Our ref: Horton Grounds Quarry, Hornton  
Date: 22<sup>nd</sup> October 2020  
Your ref: 20/02453/F

**20/02453/F - Horton Grounds Quarry, Hornton.**

**Application for a Fuel Depot including ancillary offices, the installation of plant and hardstanding.  
Objection on Behalf of The Trustees of the Lord Bearsted – 1986 Settlement (the Upton Estate).**

Title: PROPOSED SITE LAYOUT

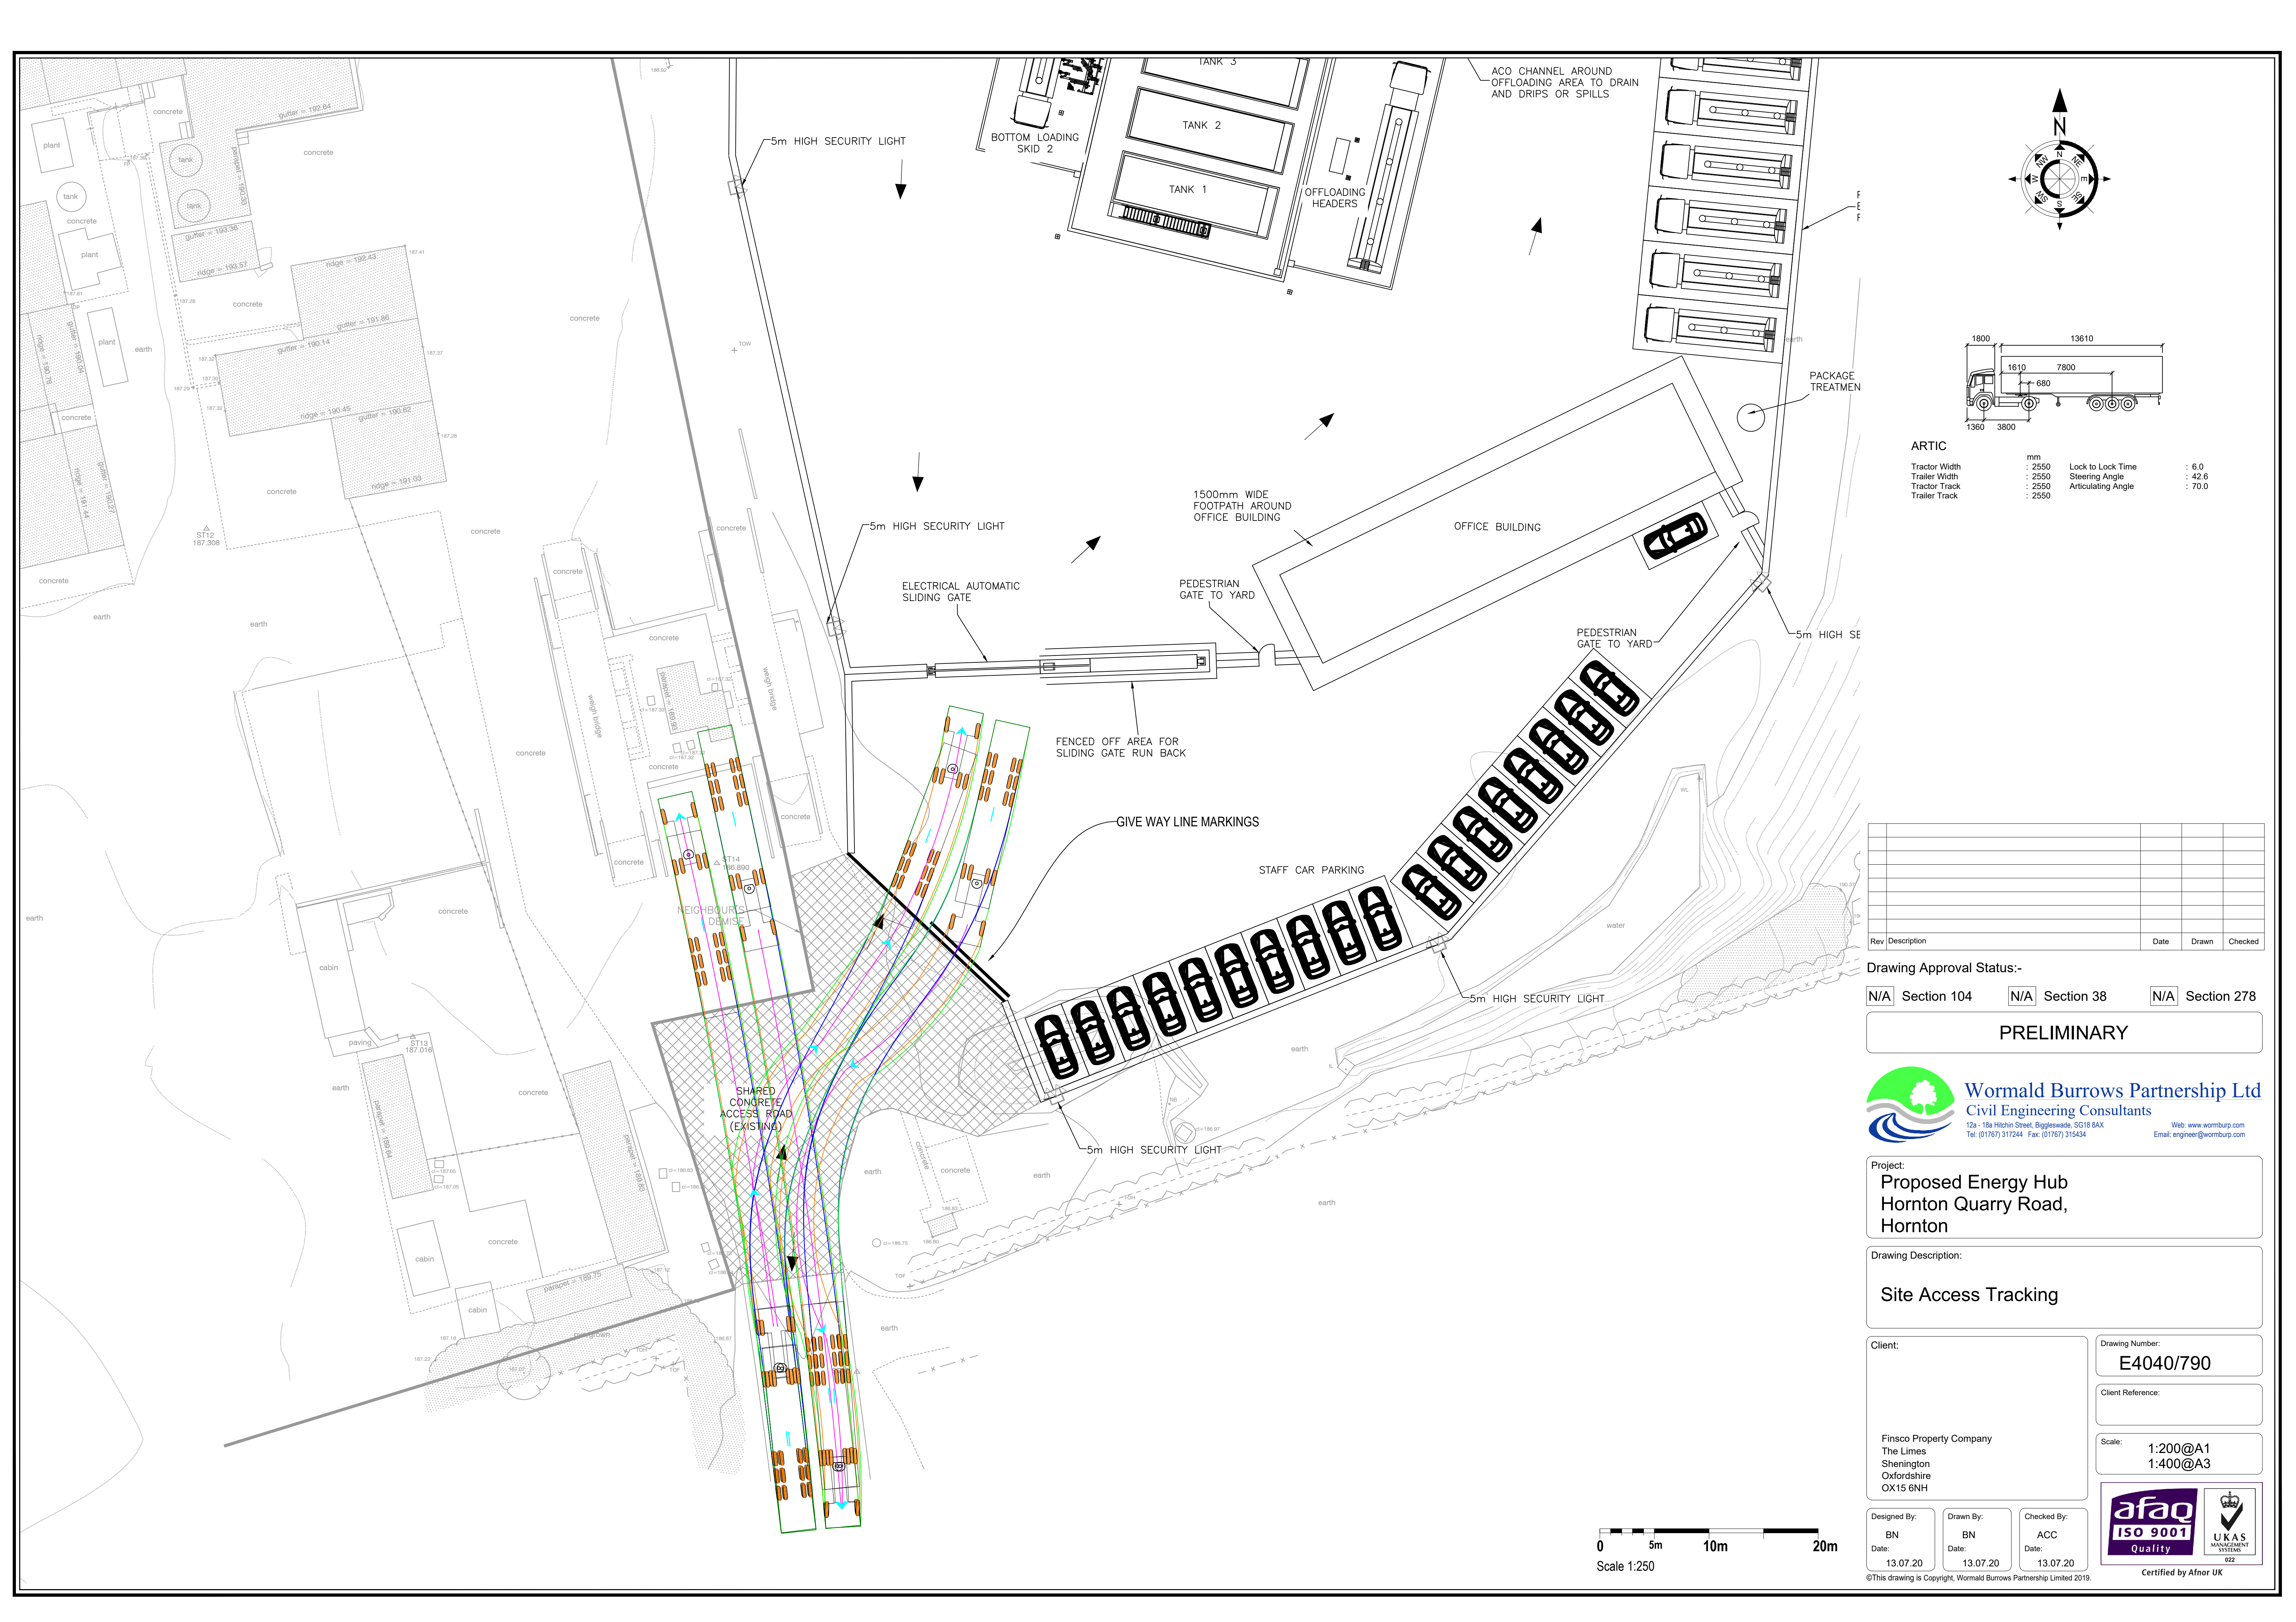
The layout plan submitted with this application indicated 10no. 5m high lighting columns will be erected as part of the development. It is important to note that this is the same number of lighting columns proposed

The consented B2 use (albeit currently vacant) will naturally have some lighting associated with it, however this intensification and expansion of the site will likely lead to significantly more lighting being required. The proposals are therefore considered to have a detrimental impact on the landscape at this location, particularly in relation to the significant harm it will cause to the dark skies and rural setting of the nearby AONB.

We have significant concerns about the adverse highway impact that will arise as a result of these proposals. It is unclear whether sufficient visibility splays can be achieved onto the A422, as there does not appear to be an access drawing showing connection to the highway available. Furthermore, tracking is provided for movement into and out of the site, but no tracking is available for access and egress onto the A422 (as a side point the red line for the application site must adjoin the adopted highway).
